From: Jeff Tarling
To: Jean Fraser
CC: David Margolis-Pineo
Date: 2/4/2016 3:47 PM
Subject: 32 Fore Street

In review of the proposed 31 Fore Street project offer the following recommendations:

TREE PROTECTION DETAIL
NOT TO SCALE

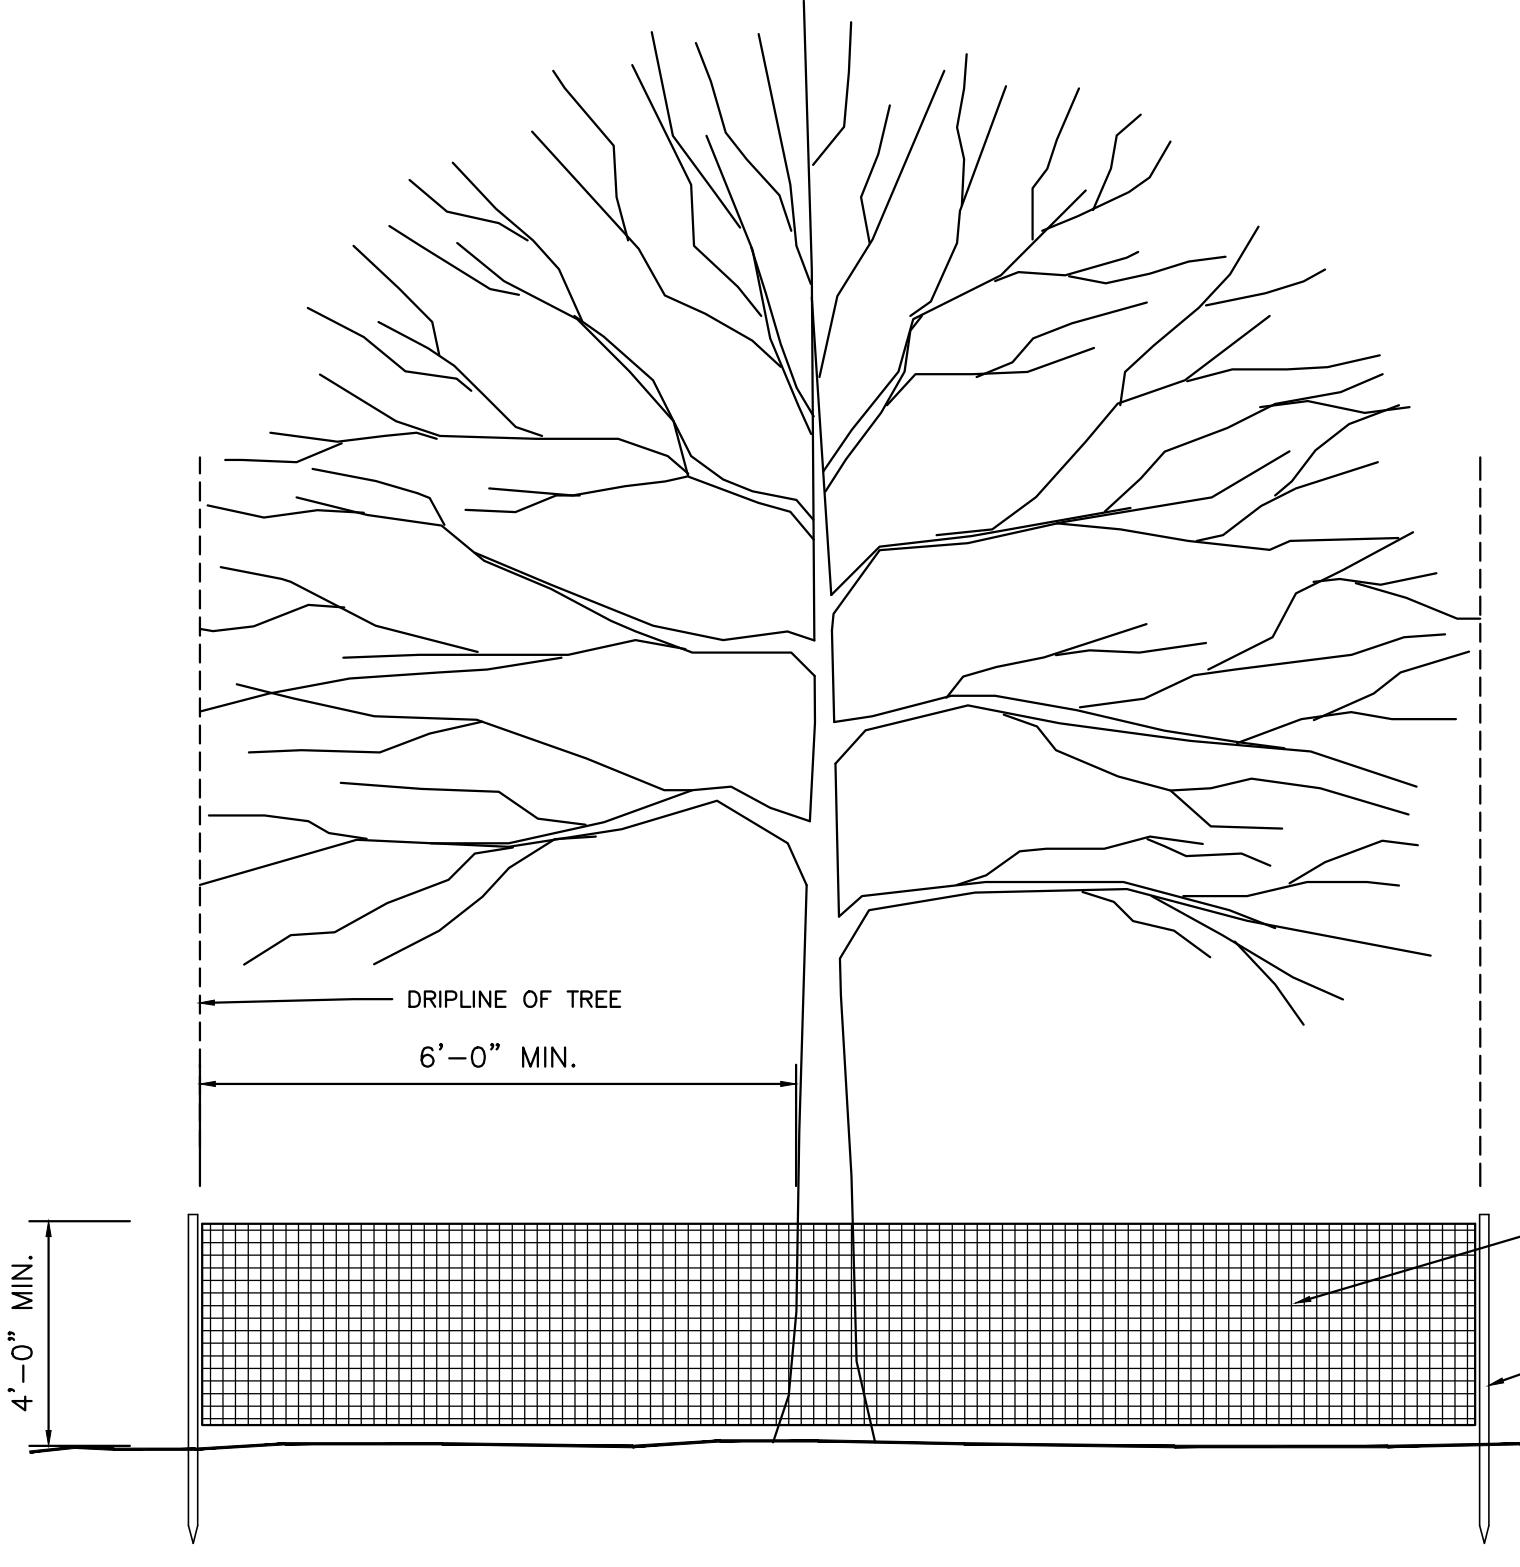
The street tree along Fore Street should be protected during construction, any broken branches damaged should be pruned as part of the project.

SOIL FILTER CROSS SECTION

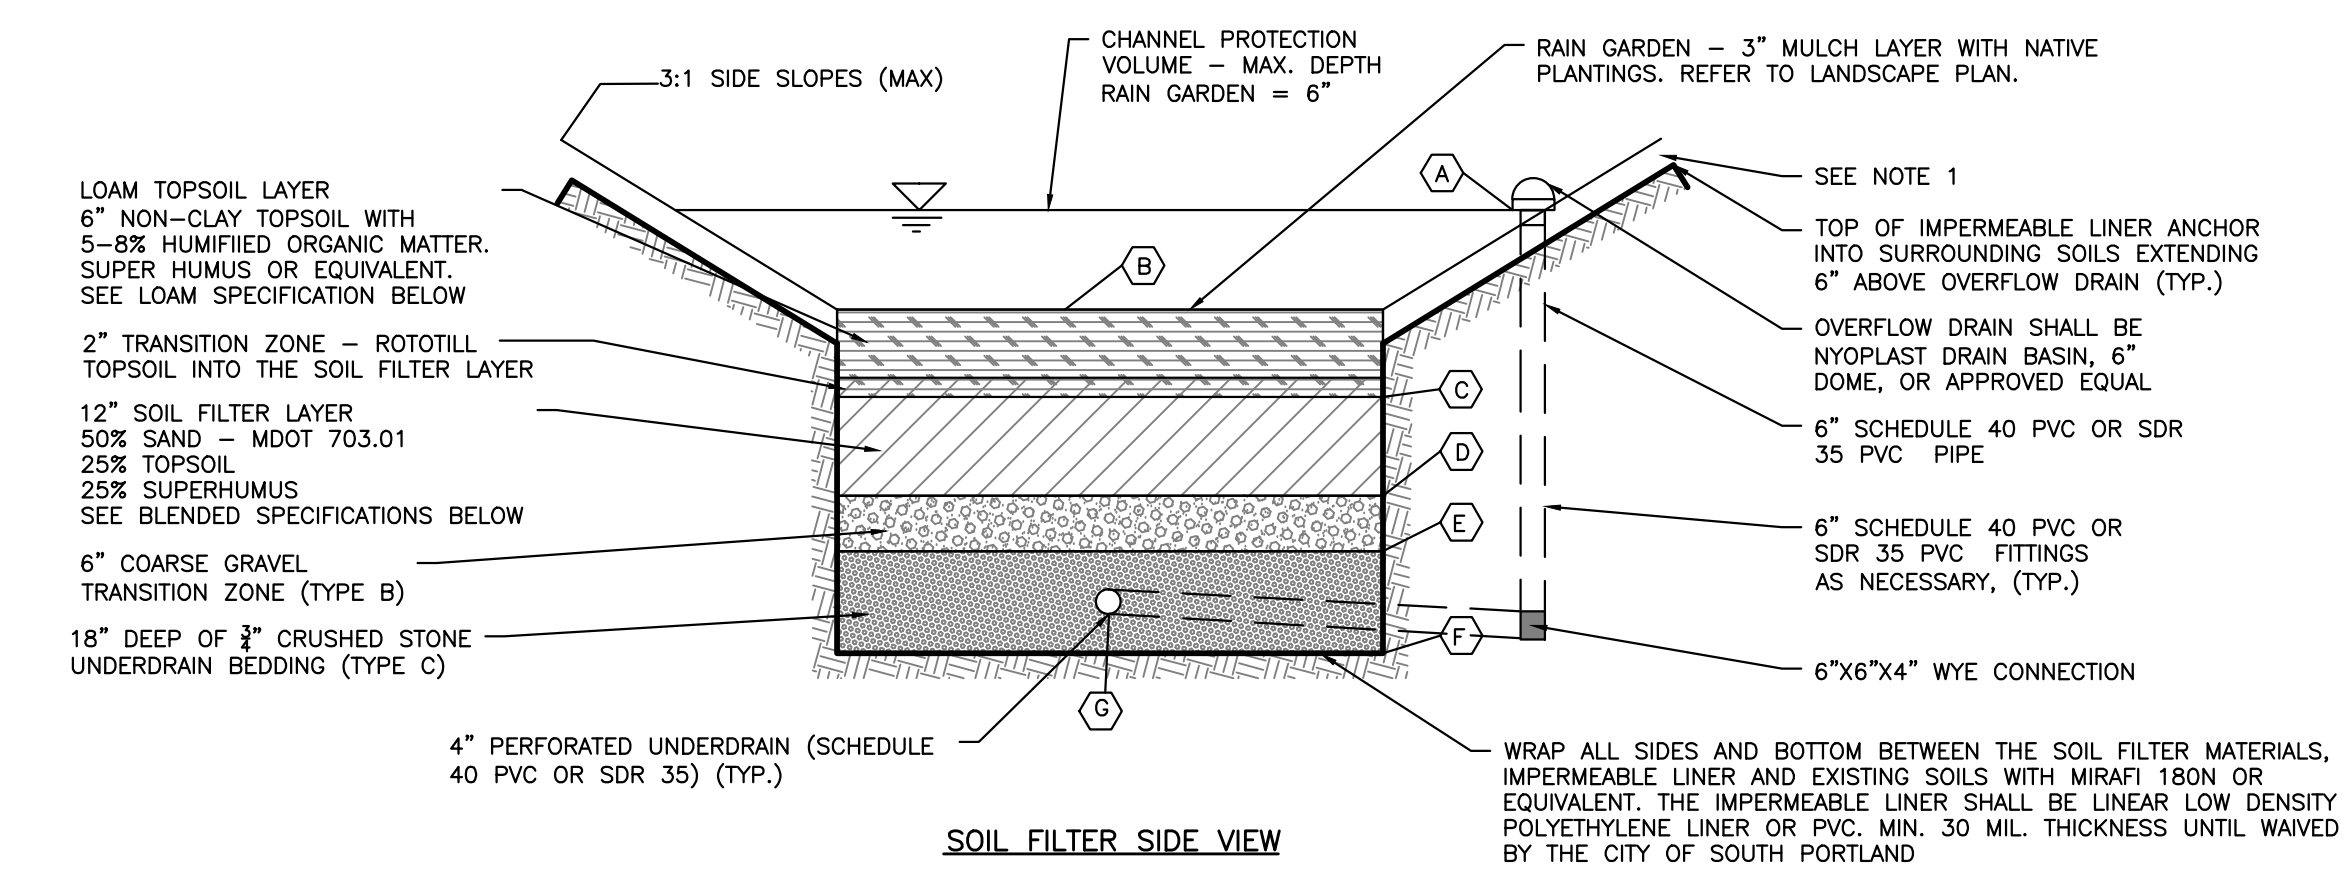
Rain Garden - Specific details on the rain garden are requested, if the project is to qualify for 'Stormwater' credits the project should follow Portland Water Resources 'rain garden' guidelines.
